May Patterson
Team Leader - Resource Assessments
NSW Department of Planning and Environment

Comments on Sutton Forest Quarries Pty Ltd – Environmental Impact Assessment

Figure 6: Modelled water table drawdown at the end of extraction operations (Coffey 2016)

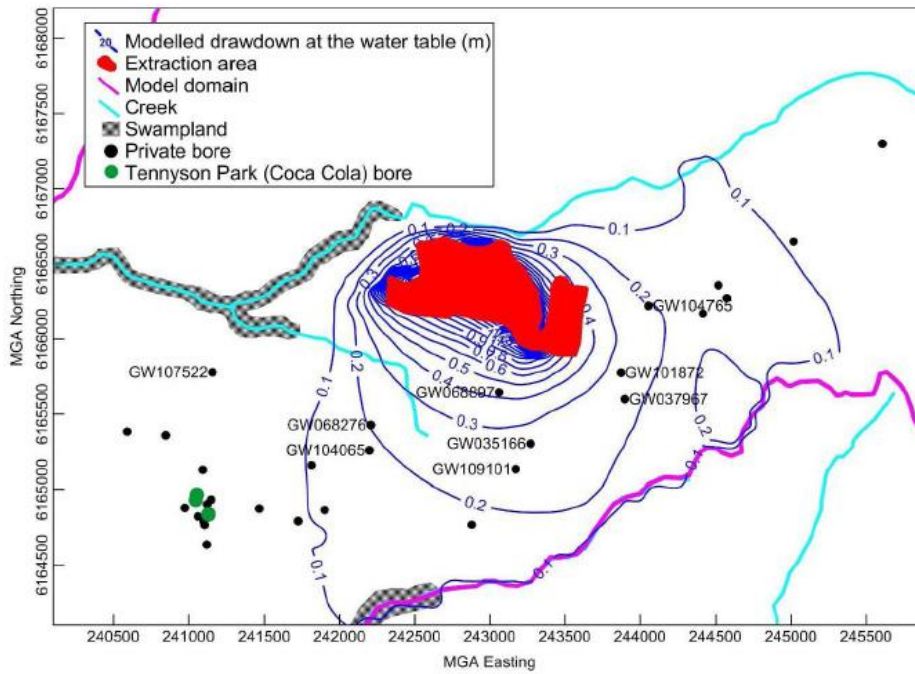
9. Groundwater capture by the proposed quarry is predicted to extend southwards into neighbouring catchments beyond the extent of the numerical model domain. For example, note how in Figure 23 on page 2-72 of Cook (2018) the 0.1m drawdown contour predicted by Coffey (2016) abuts the southern model boundary. Therefore, the model domain should be revised to assess the potential baseflow impacts to Stingray Swamp and/or Hanging Rock Swamp. The EIS should clearly report the cumulative impact of all quarrying and nearby groundwater pumping activity on all EECs. Refer to Appendix D for illustration.
